Appeal Decision

Appeal Ref: APP/Z4718/D/23/3330175

690 Bradford Road, Fixby, Huddersfield HD2 2JY

- The appeal is made under section 78 of the Town and Country Planning Act 1990 against a refusal to grant planning permission.
 - The appeal is made by Mr Harbinder Johal against the decision of Kirklees Metropolitan Borough Council.
 - The application Ref 2023/62/91595/W, dated 30 May 2023, was refused by notice dated 26 July 2023.
 - The development proposed is single storey rear extension, two storey side extension with integral garage.
-

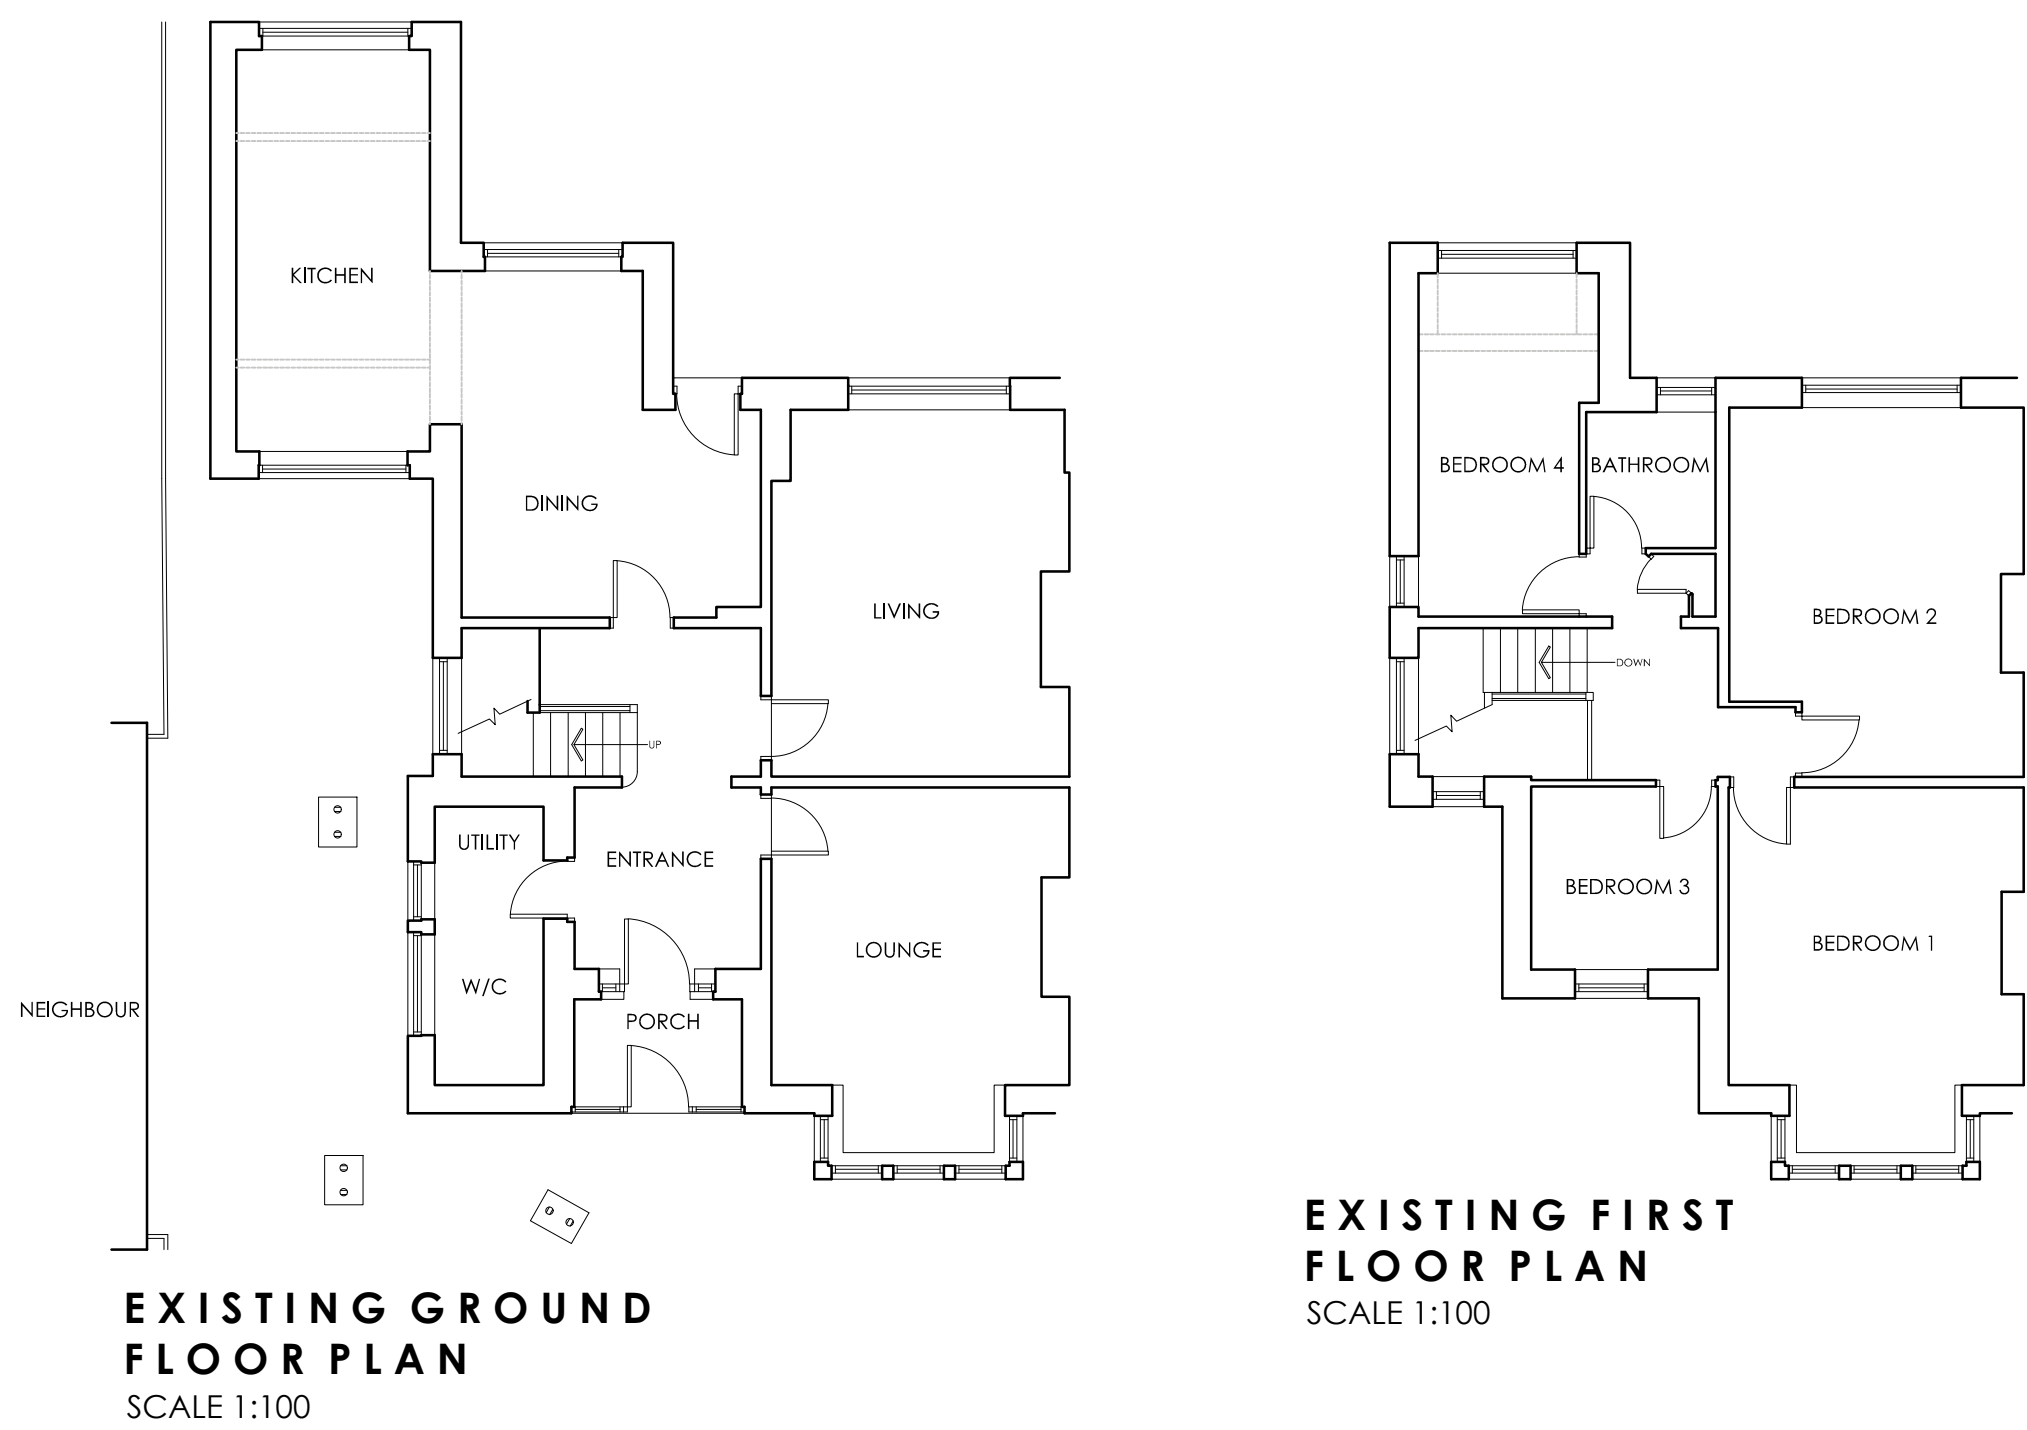
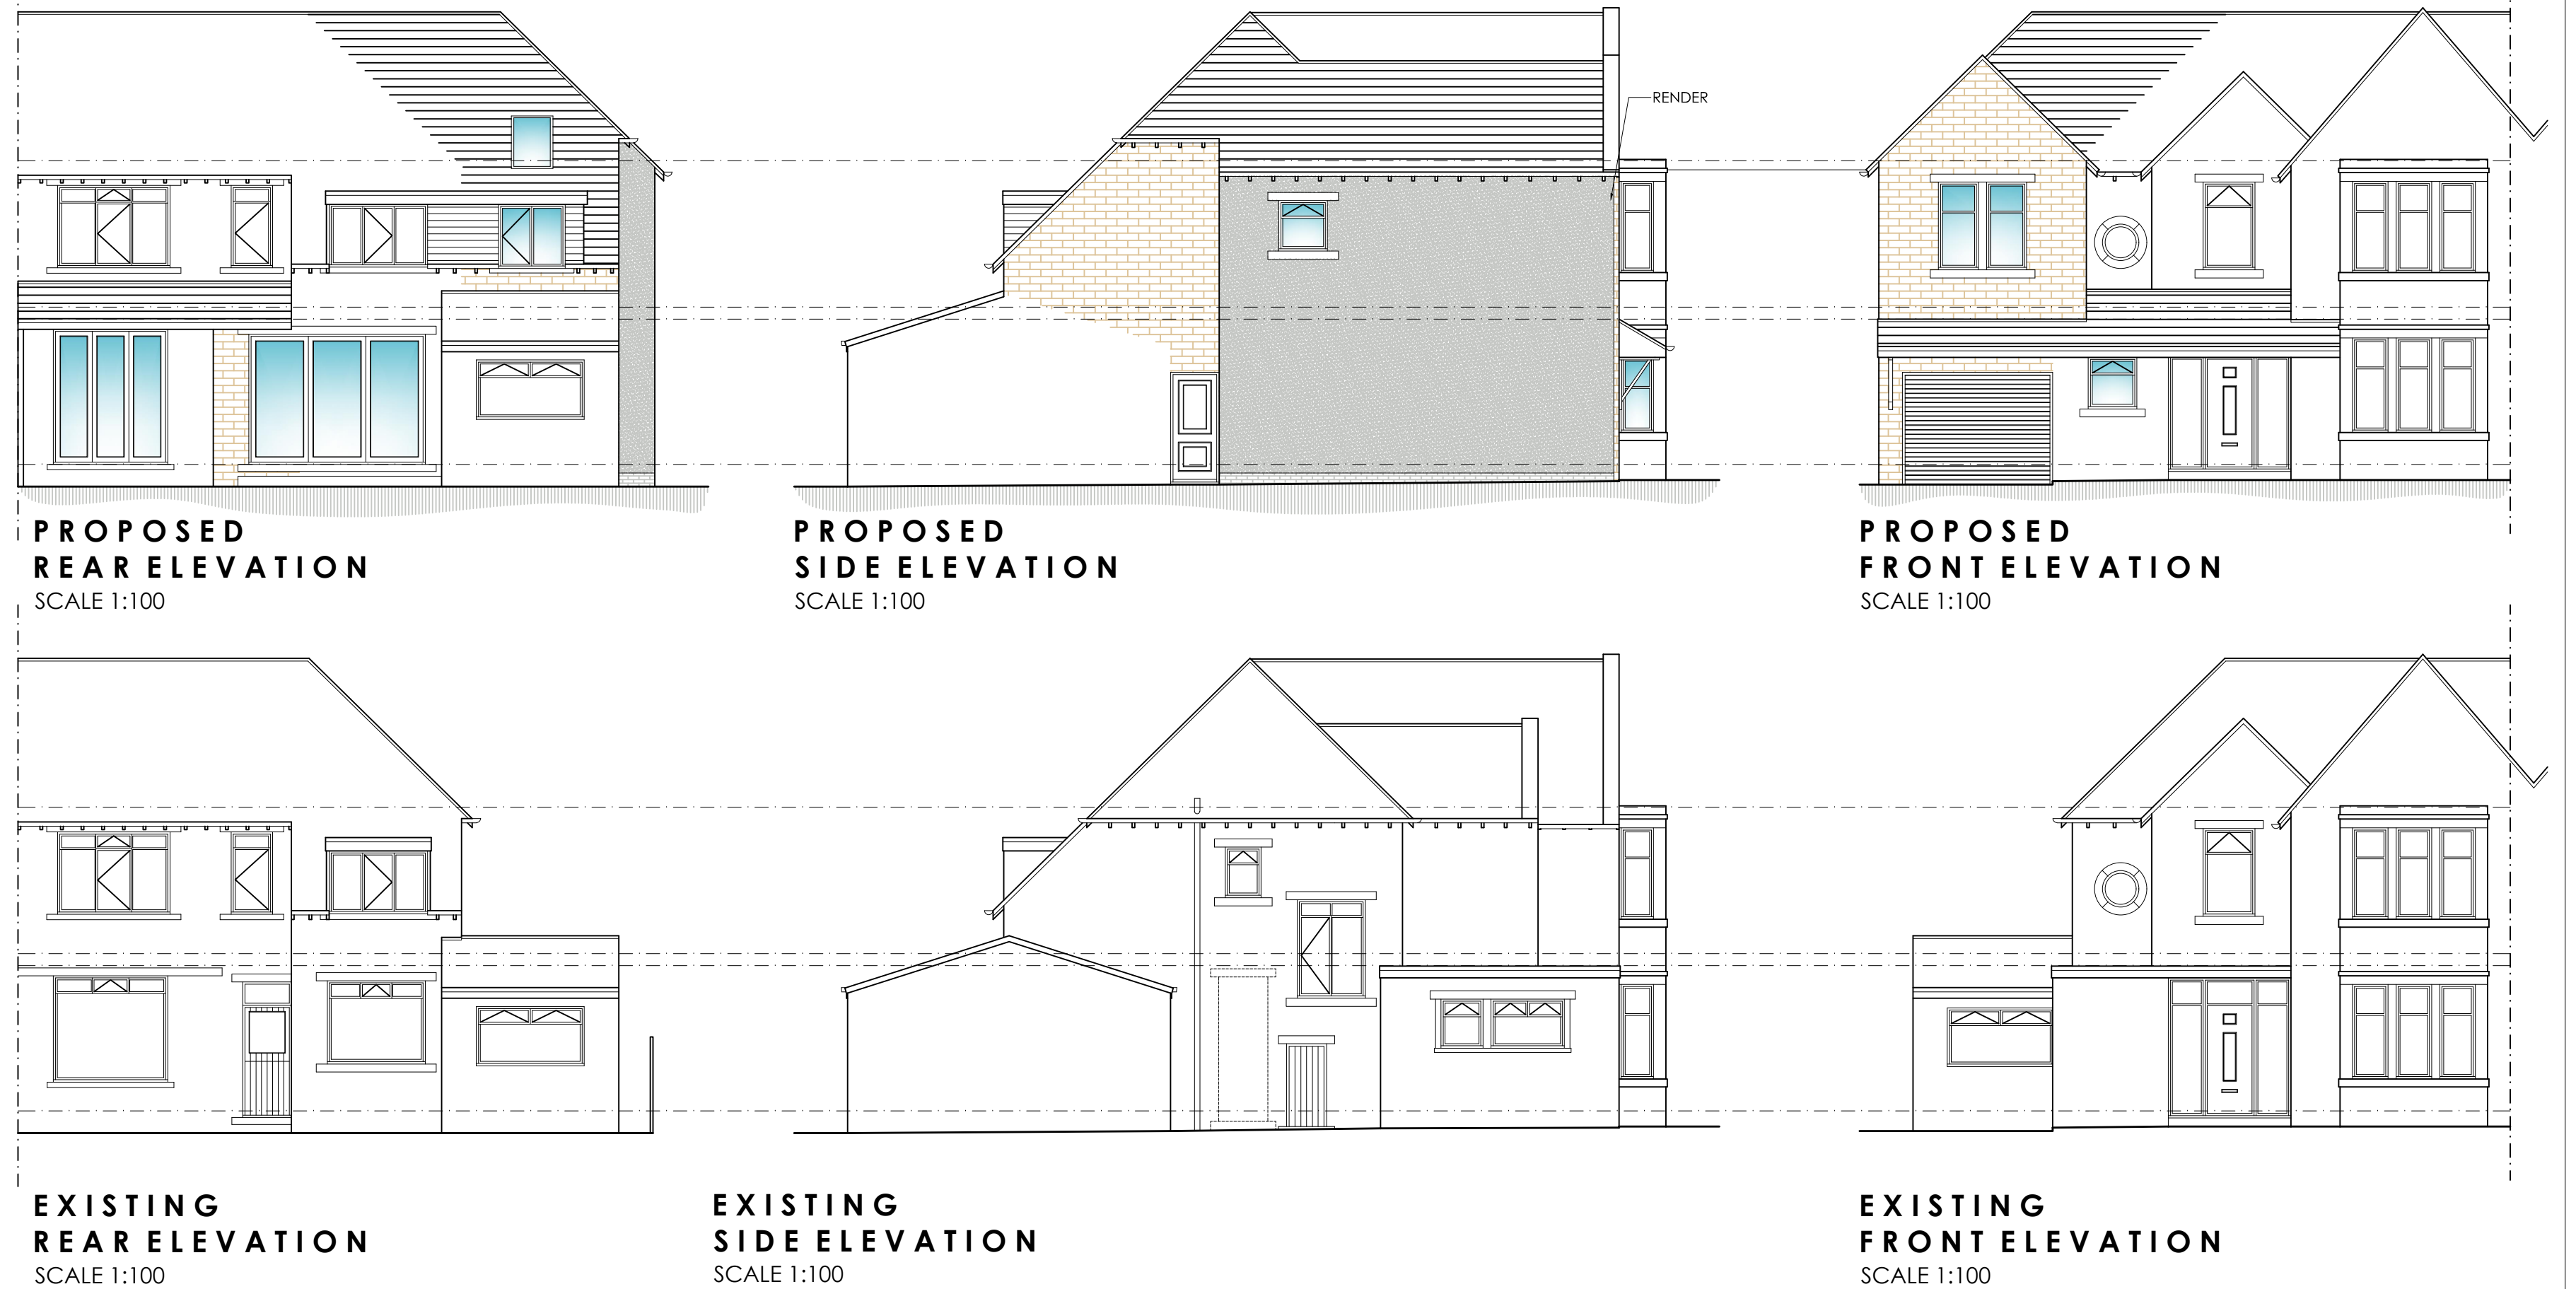
6. The proposed two storey extension would feature a hipped roof and a pitched gable to the front elevation, which would broadly reflect the character of the existing building, and it would be constructed in sympathetic materials. I also acknowledge that the proposed two storey extension would clearly have a smaller footprint than the existing building. The proposed lean-to canopy would create a visual break between the garage and the first floor to the front elevation of the side extension. Nevertheless, it would not be set back from the front of the dwelling and the extended roof would not be set below the existing ridge. The new projecting front gable would compete with the existing gable features to the front of the property, thereby accentuating the substantial bulk and massing of the proposal. As a result, the proposal would fail to achieve a subservient relationship to the host property.

7. Moreover, the combination of the length and width of the two storey extension, its proximity to the boundary with No 692, and the lack of a set back, would result in a cramped appearance and an unacceptable loss of openness between the two properties at first floor and roof level. Consequently, the proposal would not respect the spacious characteristics of the area. Although the property is set back from Bradford Road, the proposal would still be clearly visible in views along the road. Whilst I acknowledge that the site is not within a conservation area, the proposal would nevertheless be an overly dominant addition to the property to the detriment of the street scene.
